Planning Services Sign Permit Review Form

Date of Submittal	Application Number	Applicant	Landowner
8/2/2022	SIGN2208-0002	Joe Gardner	My Storage Units LLC

Sign Rendering & Site Plan

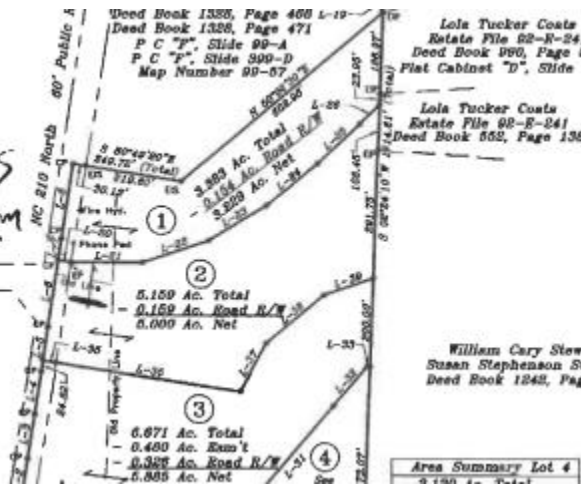
Comments	<ul style="list-style-type: none"> - Please provide the setback from the sign to the side property line. - I have attached a survey from 2019 that you may use as a site plan if it is helpful determining the distance between the sign and side property line. It may also help determine with certainty where the ROW.
----------	---
